Tel: 01903 737756
Email: planning@arun.gov.uk
www.arun.gov.uk/planning
Please ask for: Mrs D Johnson
Email: daun.johnson@arun.gov.uk
Telephone: 01903 737762
Our Ref: BE/18/26/PL
Your Ref:
Date: 25th February 2026

Application for Planning Permission

Development: Erection of 1 No detached four-bedroom dwelling (self build) with associated car parking, bike store and landscaping. This application is in CIL Zone 4 and is CIL Liable as a new dwelling.
Location: Land West Of 26 Greystone Avenue Bersted PO21 5EA

A 01

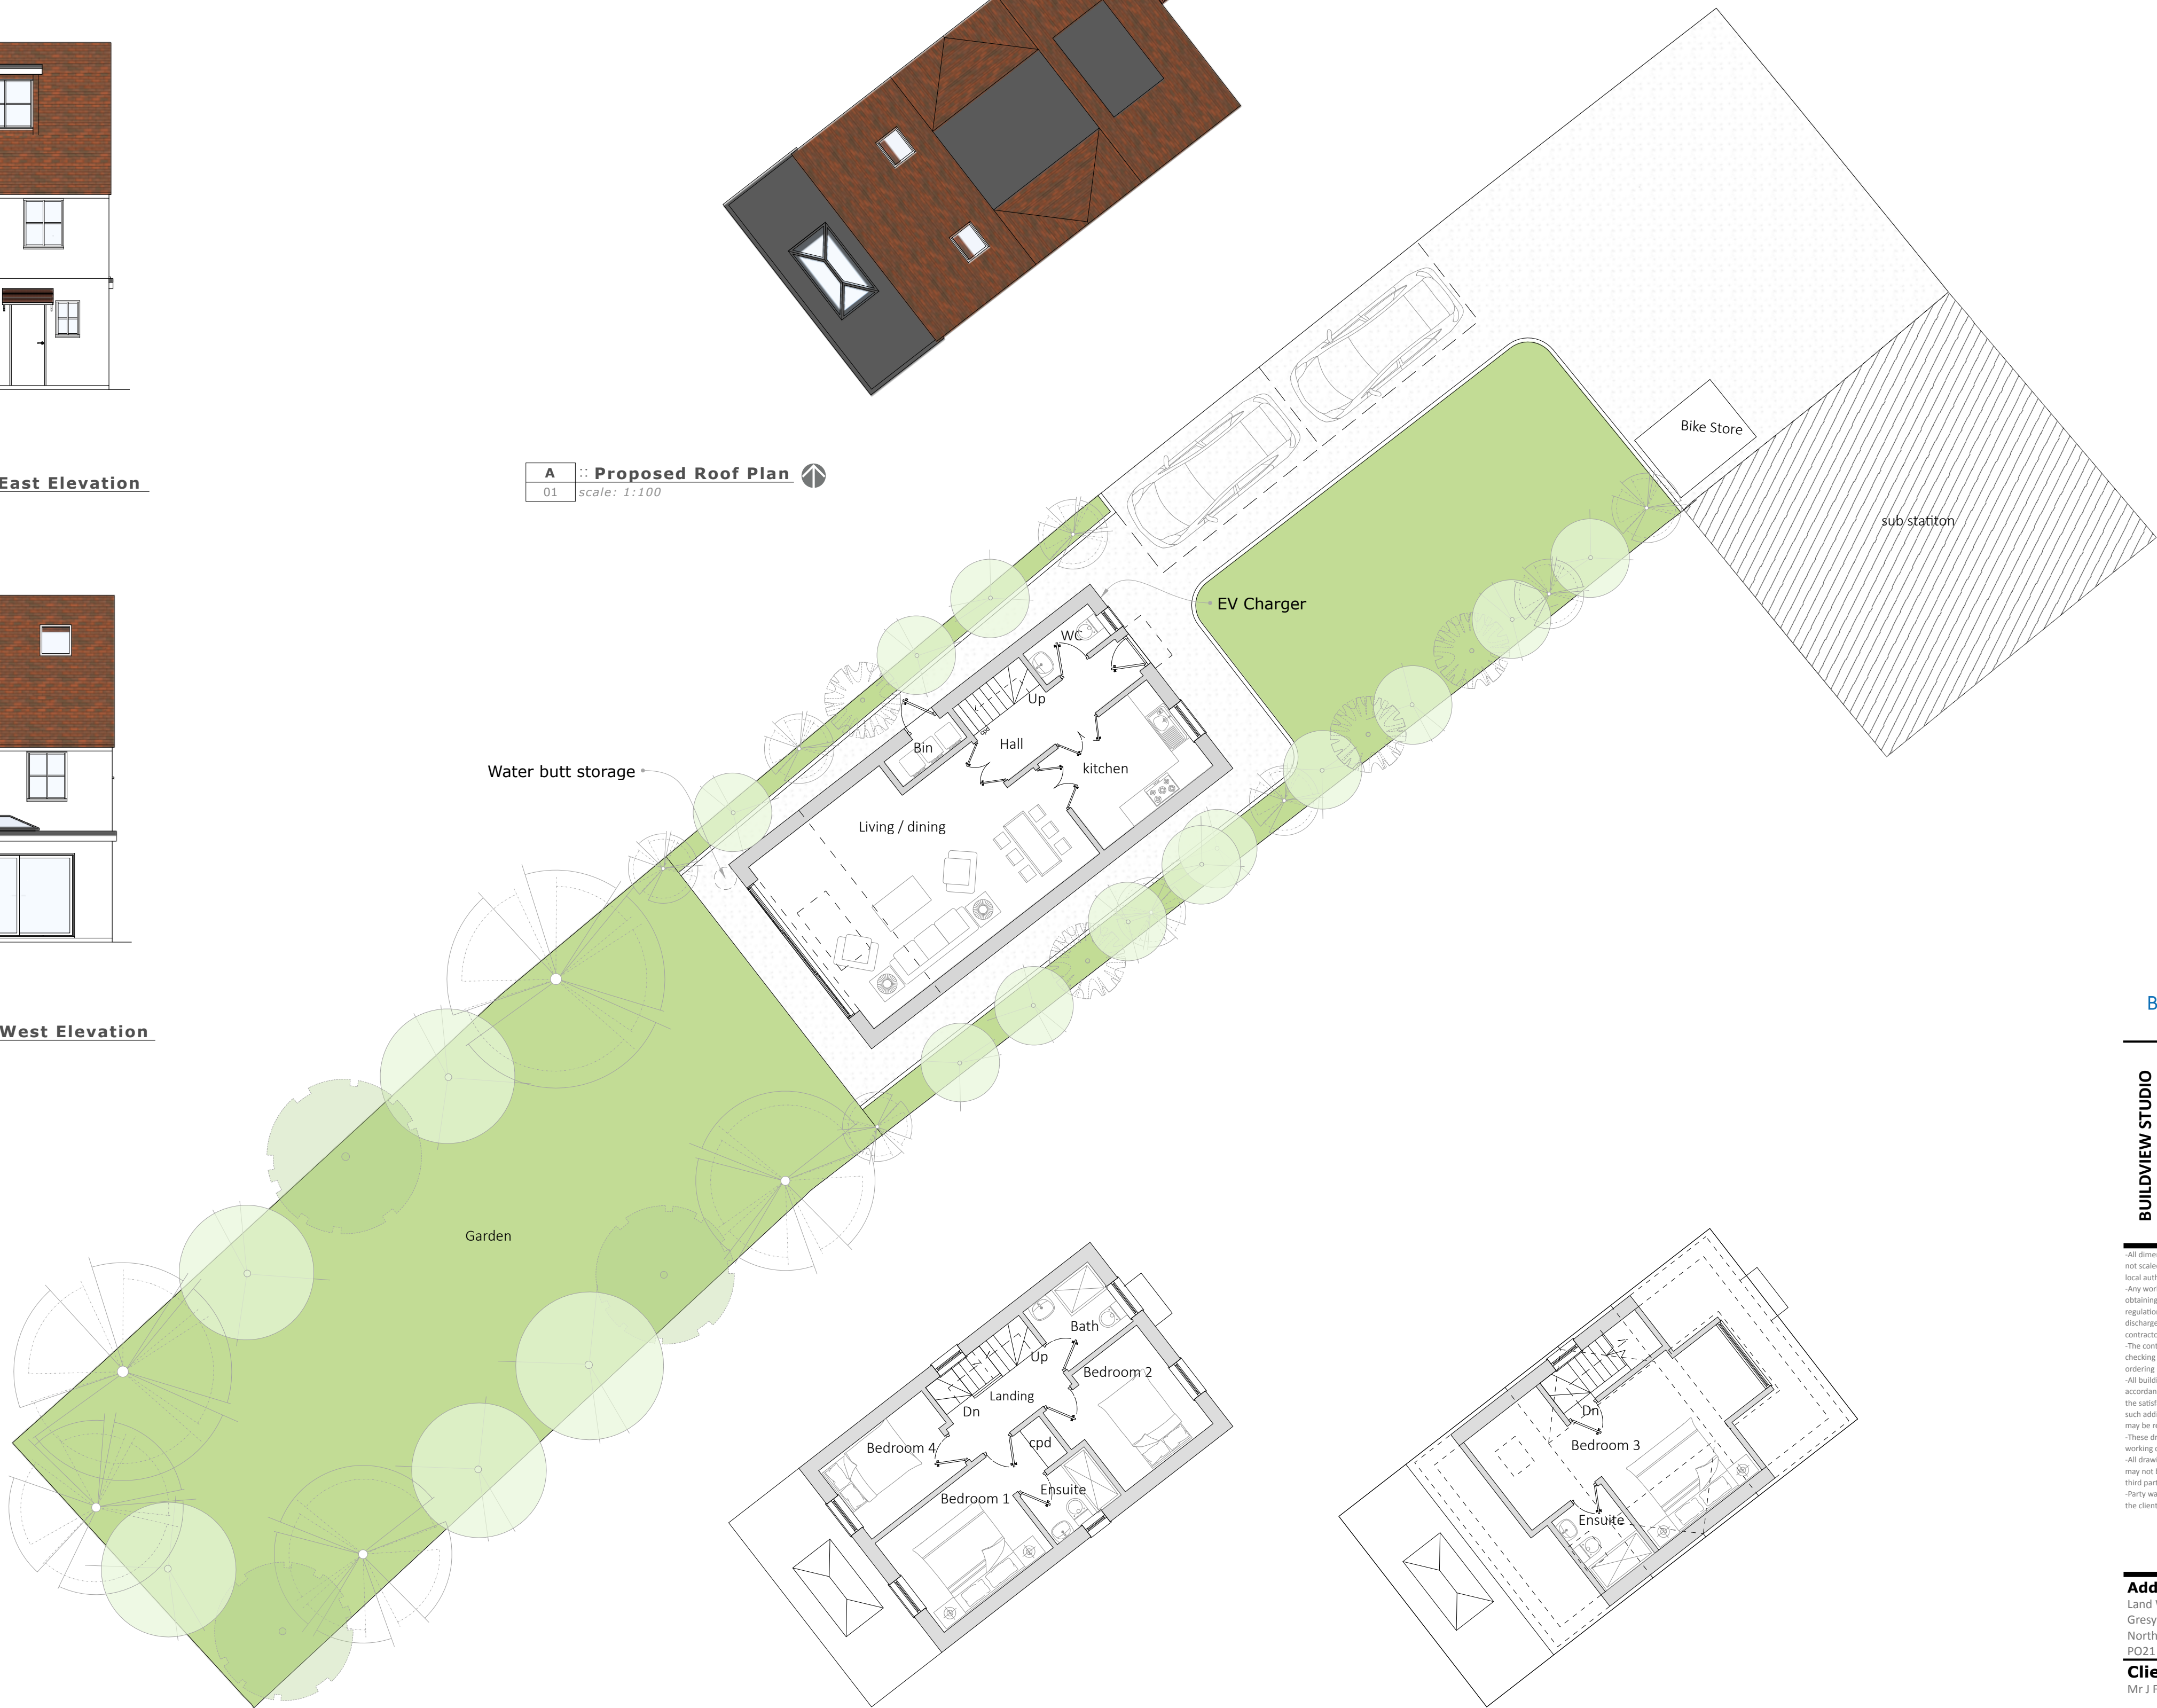
Block Plan

Please show the proposed vehicle entrance.
